18 March 2022

Buronga Landfill Expansion EIS (SSD-10096818)

WaterNSW has reviewed the associated documentation and makes the following comments:

WENTWORTH SHIRE COUNCIL
BURONGA LANDFILL EXPANSION
FIGURE 10
STORMWATER MANAGEMENT STAGE 1

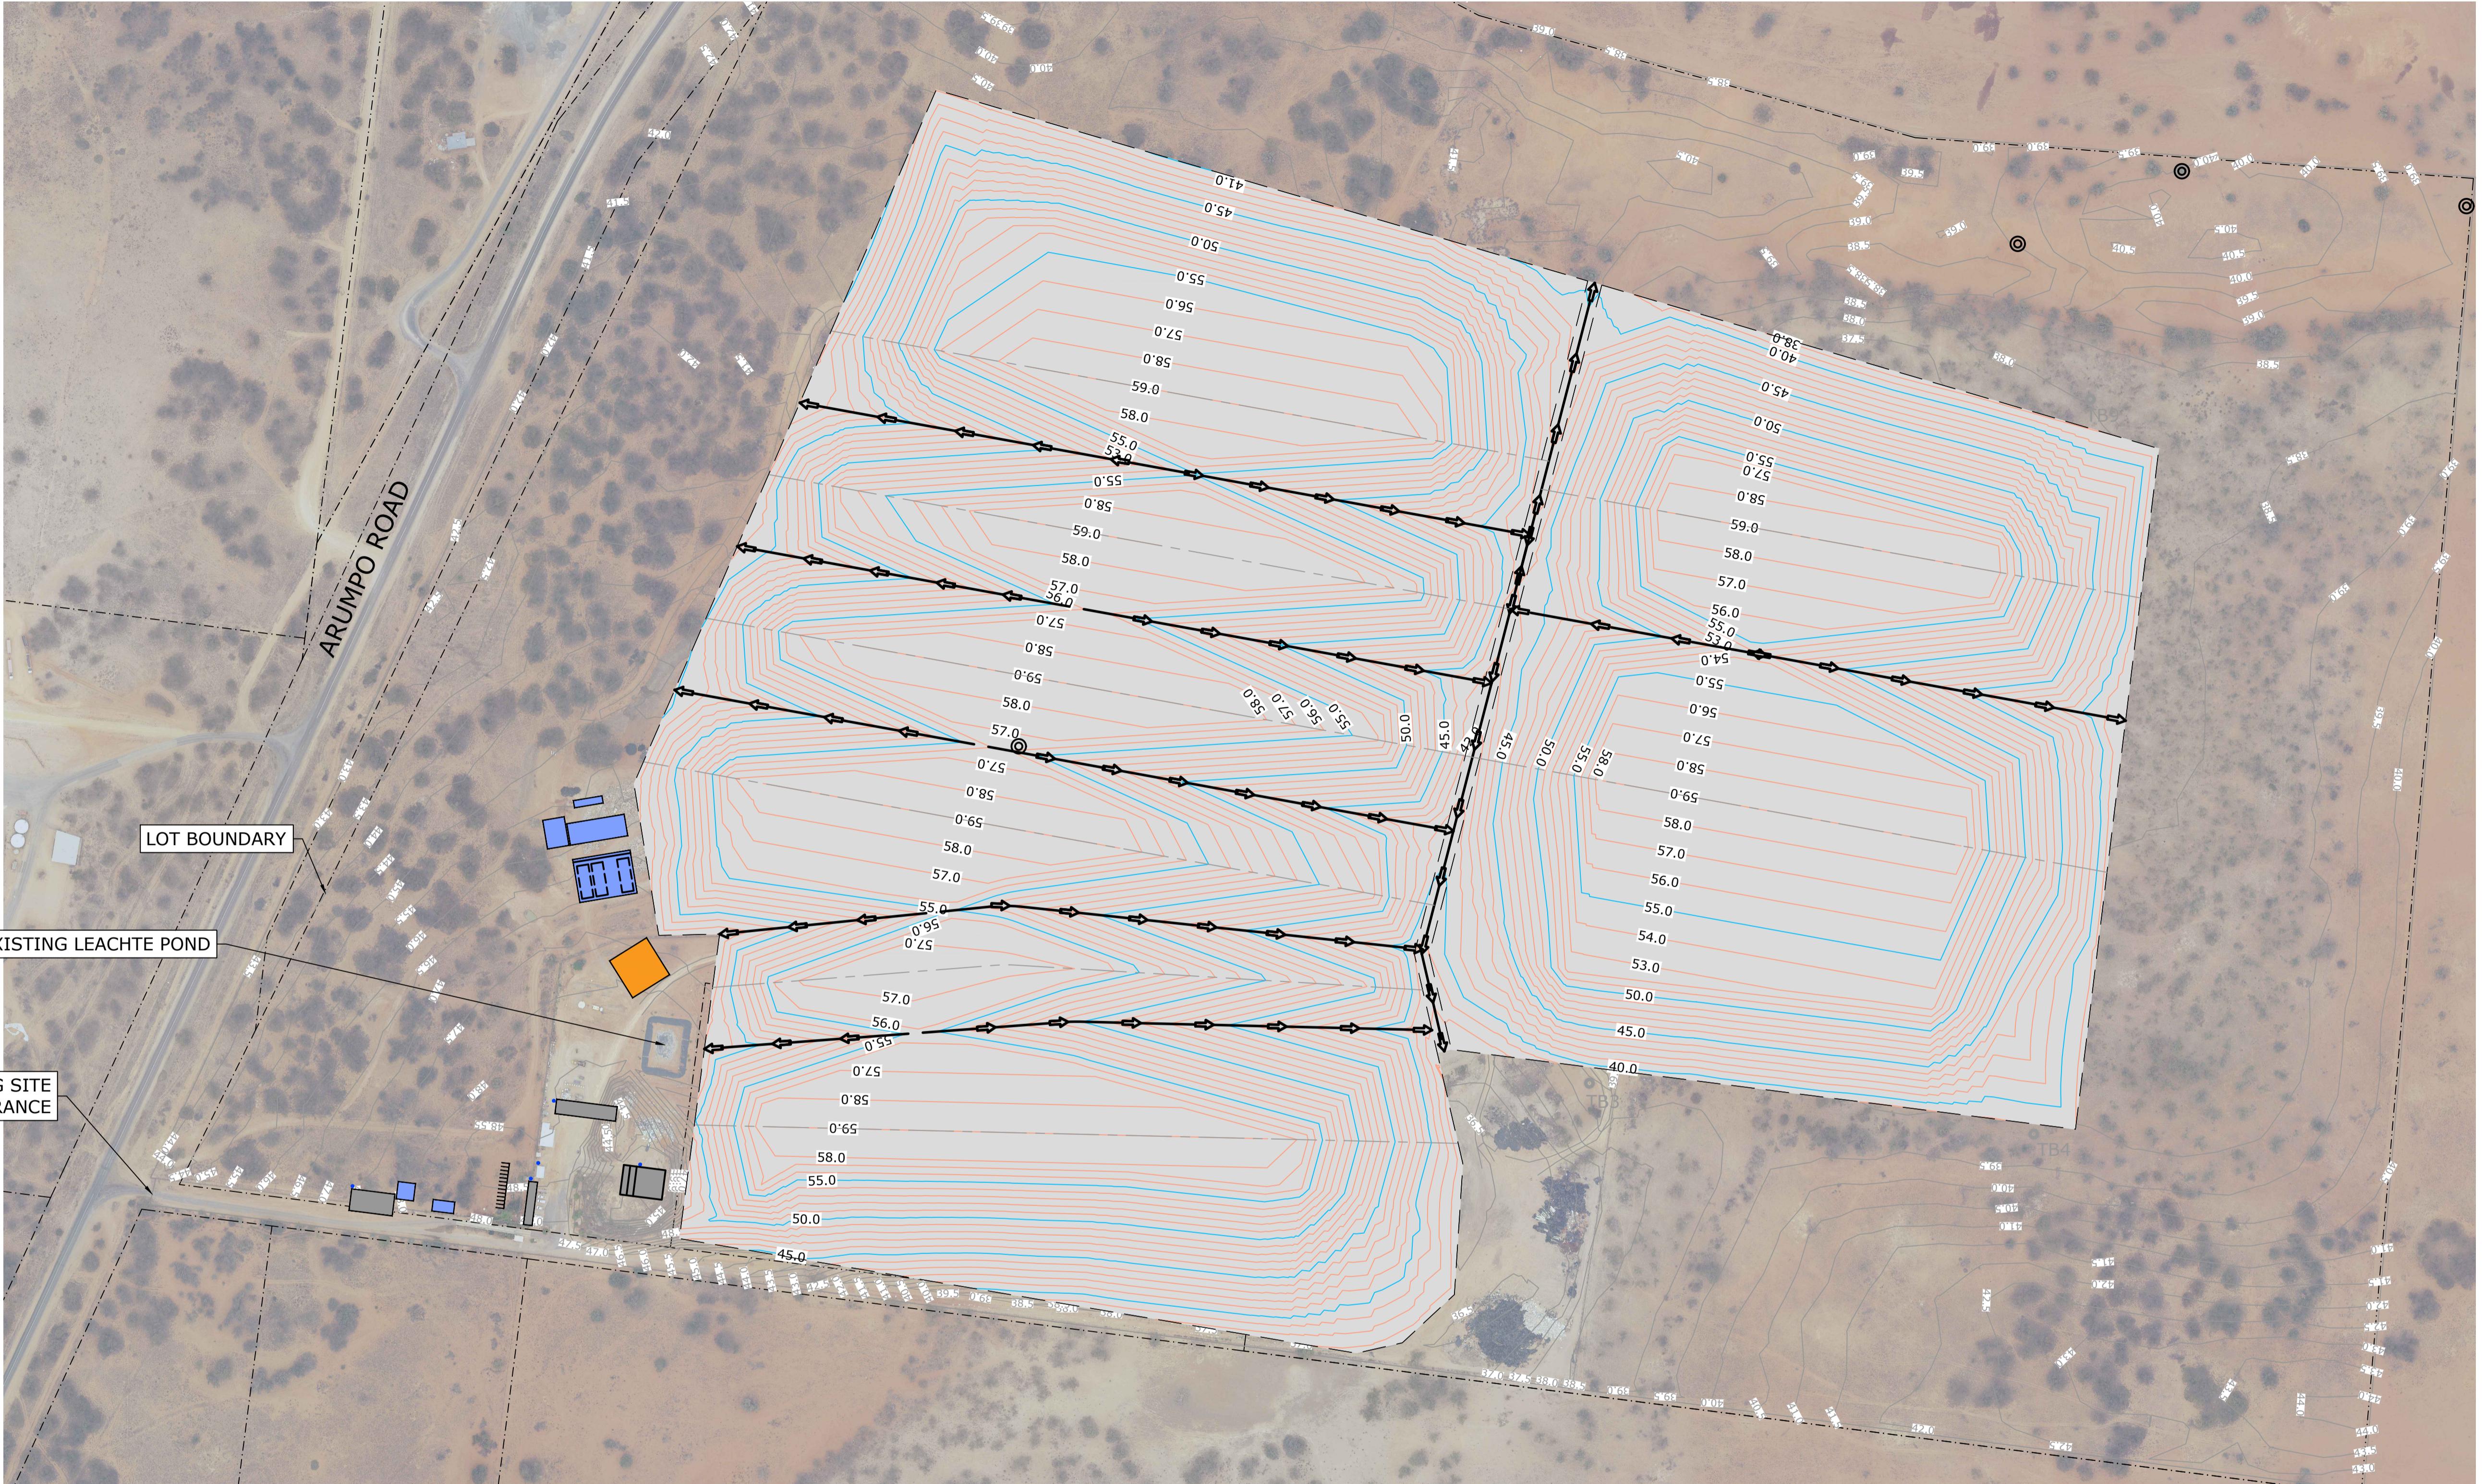
- The impact on the existing groundwater monitoring bore (GW087083) located onsite is not considered in the EIS. This includes impact to the monitoring site itself from the landfill expansion and impact to access from changed conditions onsite.
- It is unclear from the assessment whether the proposed new stormwater detention pond, north of Area 7 (EIS figure 10) will impact on the GW087083 monitoring bore.
- WaterNSW supports the recommendation made in the EIS (section 6.3.4) to install groundwater monitoring wells to monitor groundwater and water quality data prior to construction and during operation. It is noted that the mitigation measures contained in section 6.3.4 are not all included in table 7.1 under groundwater.

WaterNSW requests that the impacts to the existing groundwater monitoring site be considered and addressed in the Response to Submissions, including advice on asset protection measures and suitable access arrangements. If the impacts cannot be adequately mitigated to avoid impact, then development near this existing asset should be reconsidered. In addition, all mitigation measures recommended in the EIS should be included in a comprehensive summary table to ensure all measures are captured and can be conditioned.
